Please upload the attached as an amended plan for A/146/19/PL.

Heathens/Arun Road/Angmering BN16 7EL

Rev	Date	Revision Details	Dr	Ch
P4	17.12.19	Amendments following planner comment.	JT	AK
P3	25.10.19	Revised notation.	JT	AK
P2	25.10.19	Revised red line and road name correction.	JT	AK
P1	17.10.19	Planning Issue.	JT	AK

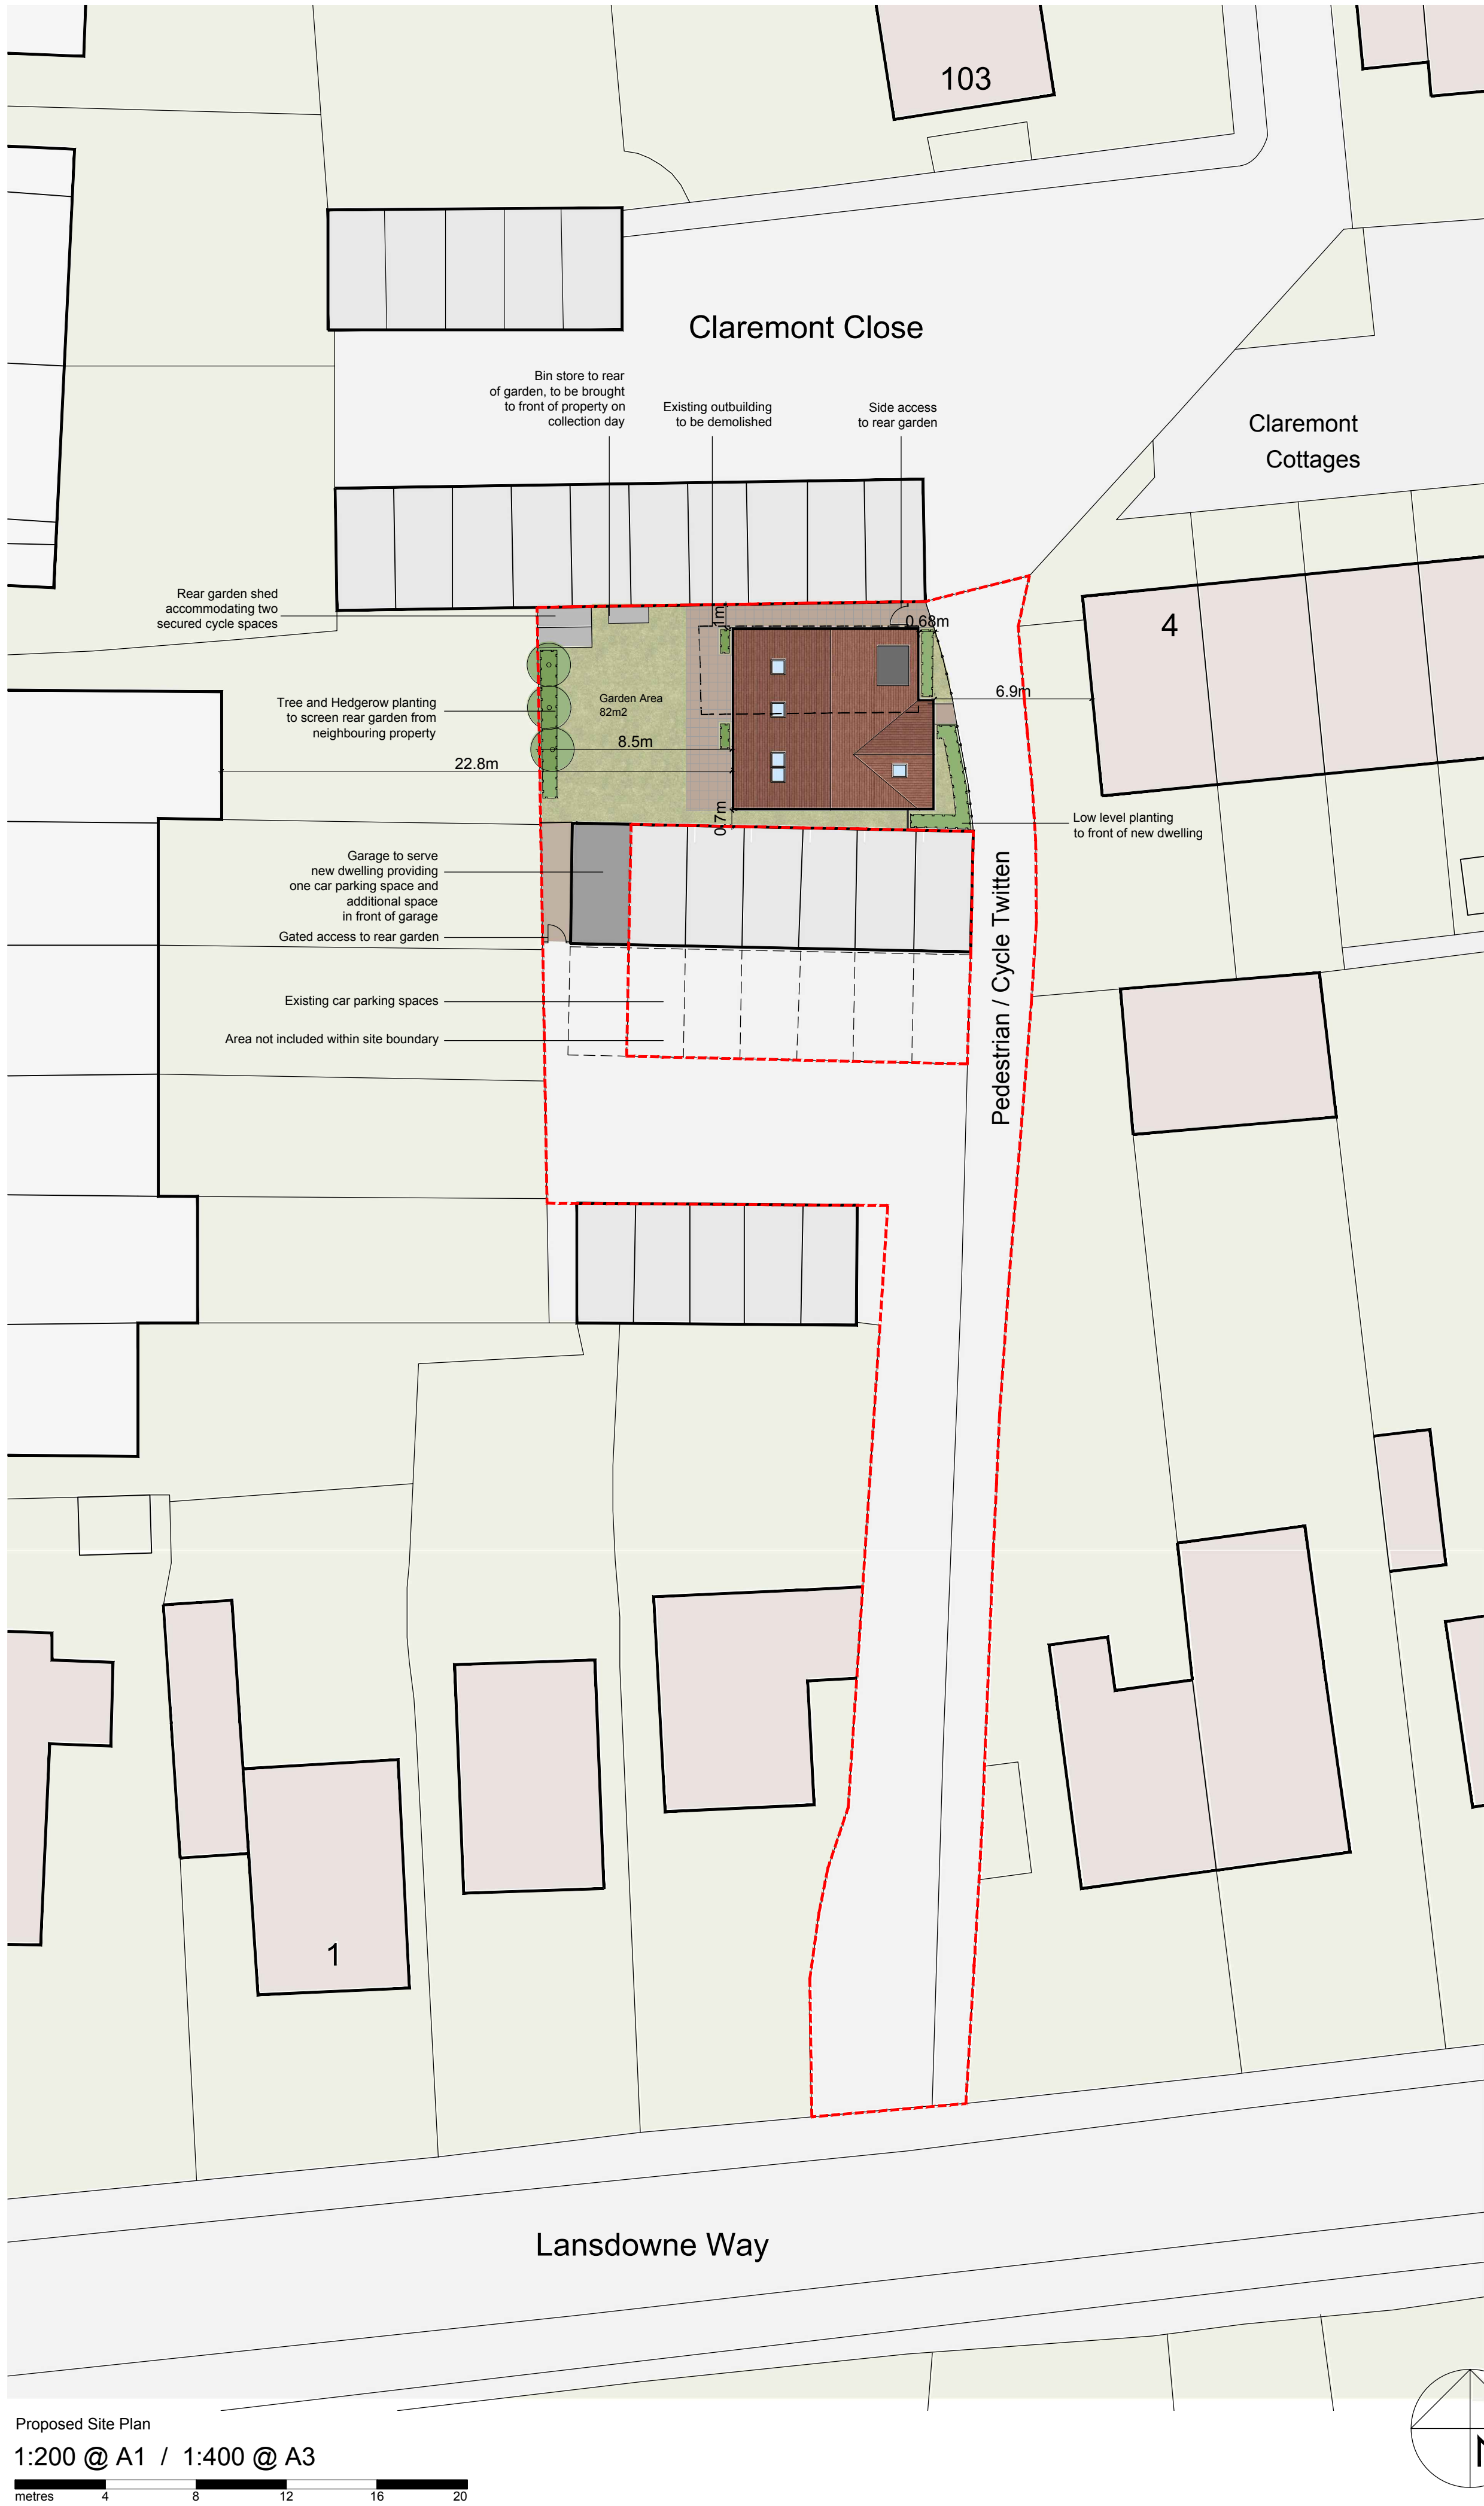
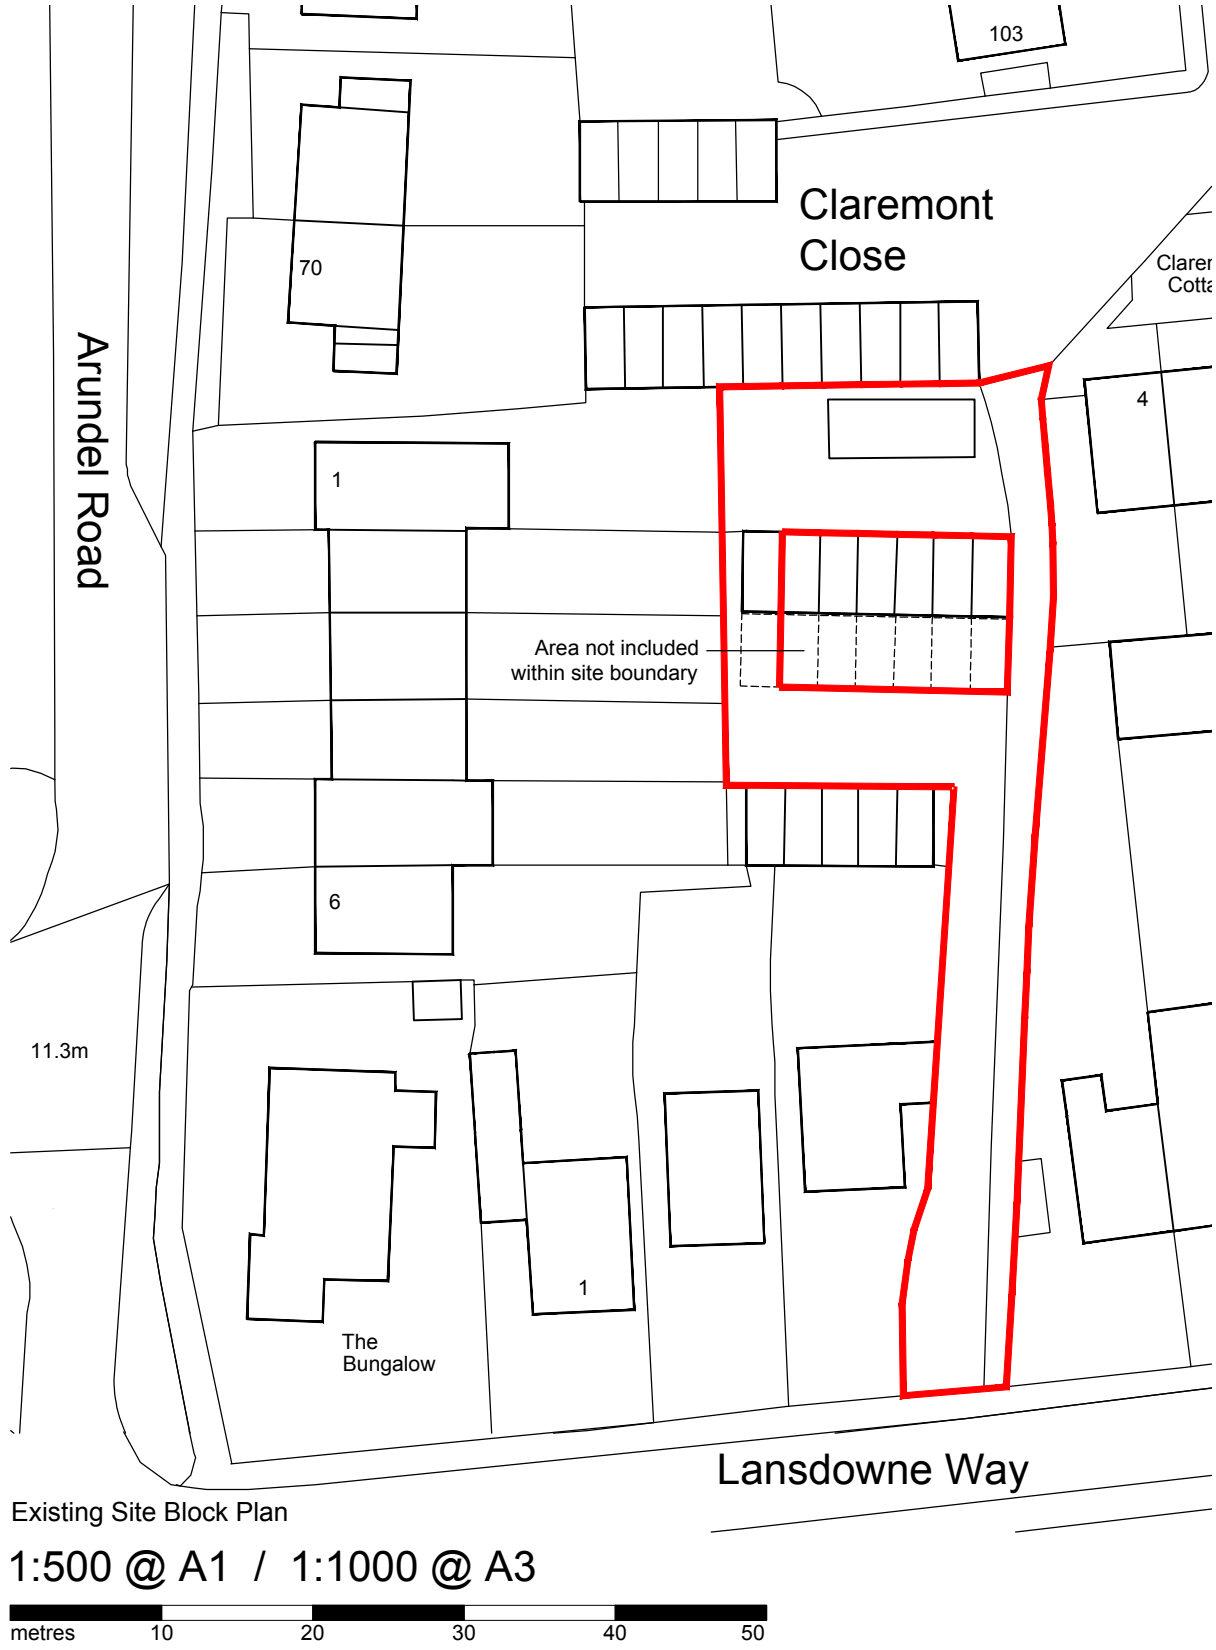
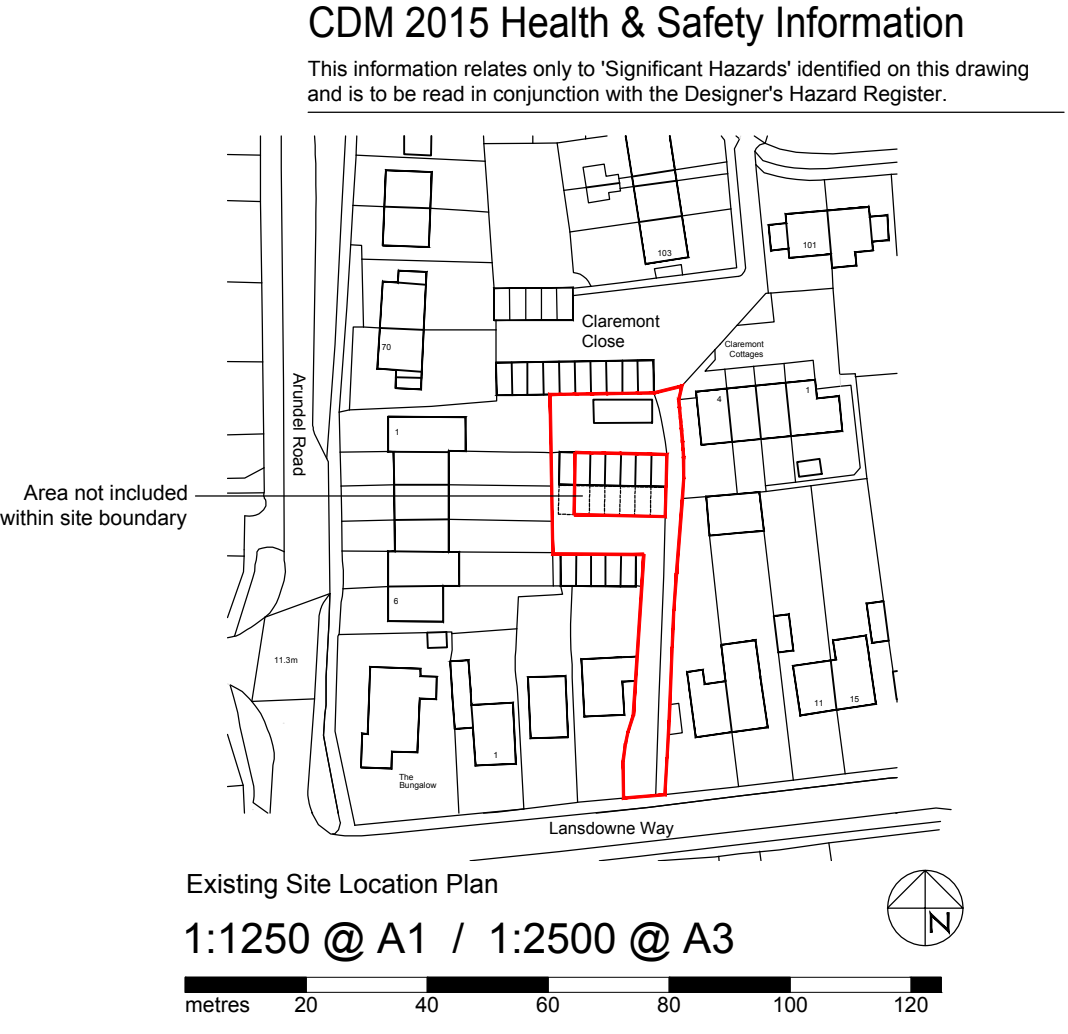
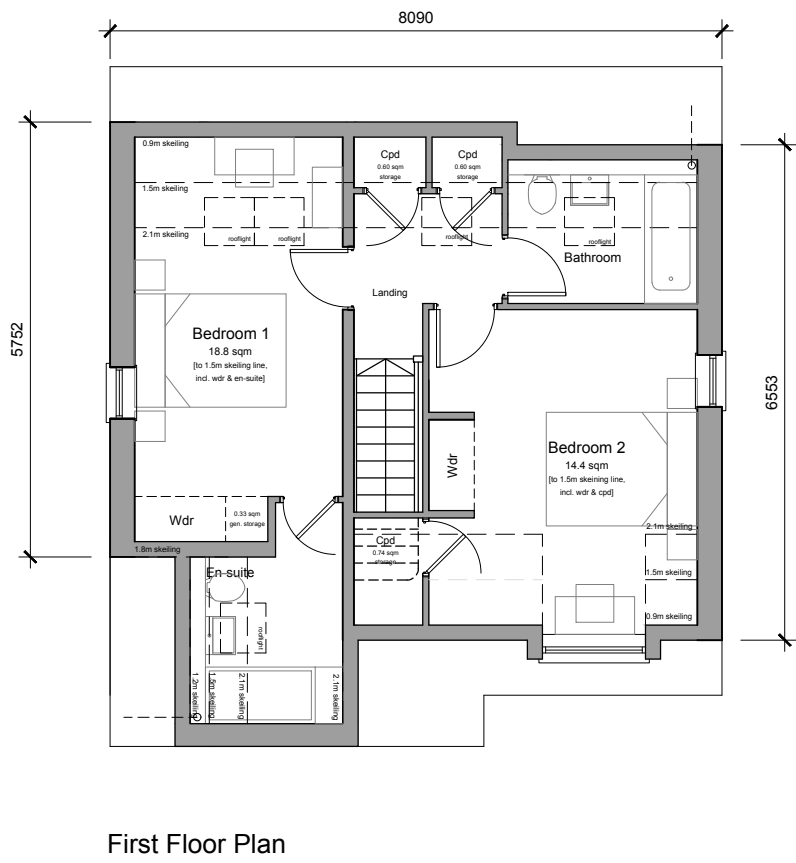
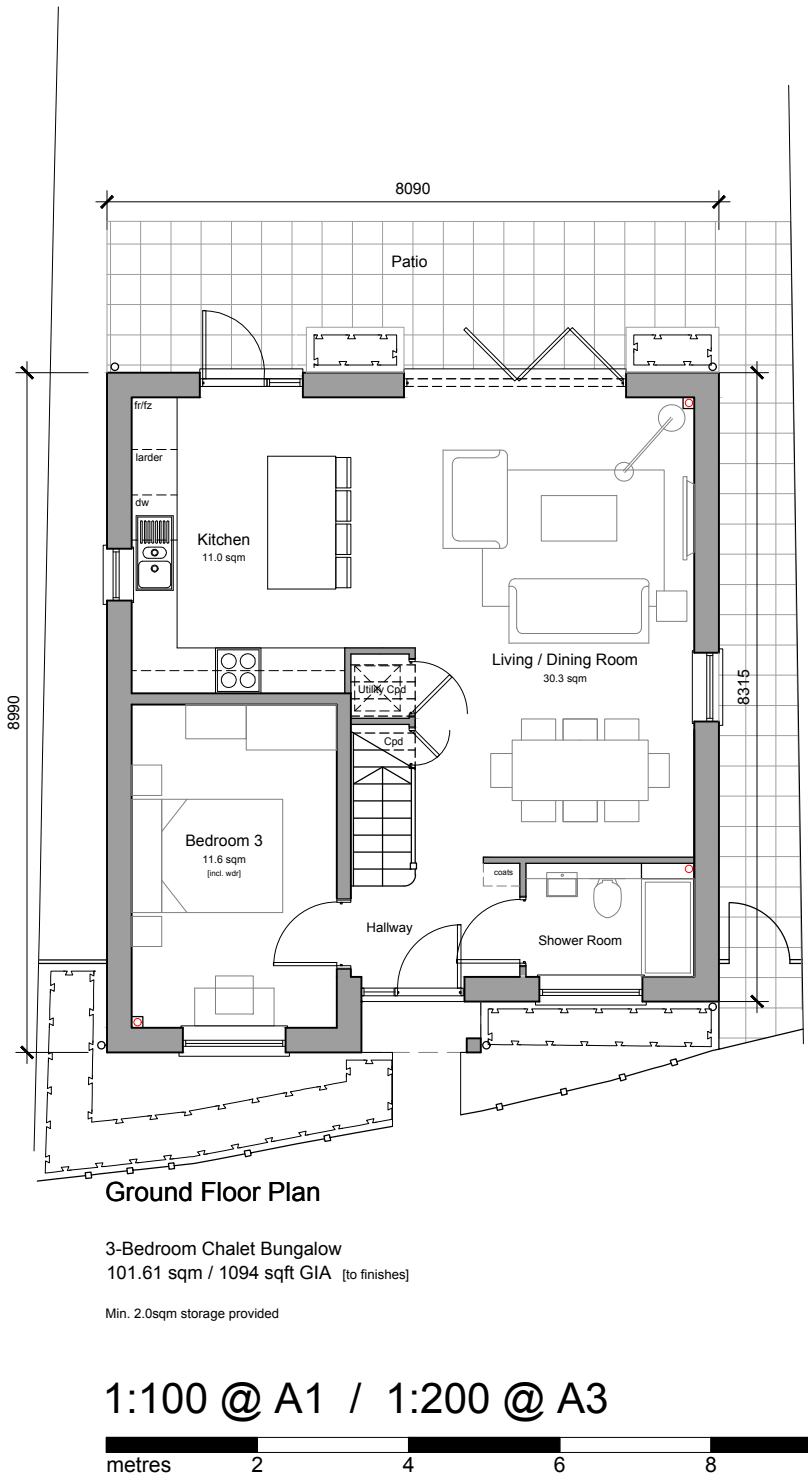
I had a chat here internally and we feel the proposal could be ok, on balance once a few changes are made. I mentioned your willingness to make whatever changes we felt necessary to get it over the line. Could you send in an amended plan removing the rear dormer (replacing it with a rooflight) and squaring off the rear elevation so that the rear garden depth would now be 8.5? If you wish you could slightly enlarge the dwelling at the front elevation to get back some internal space.

A rear garden of 8.5m in depth at maximum and 6.3m for the majority is less than what's recommended. As I'm sure you know 10 or 11m is looked at as a minimum depth. Although the principle of development is ok other issues such as above and the hemmed in nature of the proposal in relation to the rows of garages on either side are likely to be other issues for this proposal. I will have a closer look at 'Red Admiral Bungalows' and if possible visit this site when on site next week.

Your suggestion and willingness to make further amendments to the proposal in terms of the rear gable end and rear facing dormer window are also noted. However before I ask you to make any amendments I would like to carry out that site visit to see if this is what's needed to bring the proposal to a positive conclusion.

Please find attached an amended drawing containing the changes that you have requested – (1) removing the rear projection so that the entire garden depth is 8.5m, (2) removing the rear dormer window to Bedroom 1 replaced with 2no. roof-lights at 1.5m height in order to ensure no possibility of overlooking, and (3) and very modestly enlarging the front elevation in line with your comment.
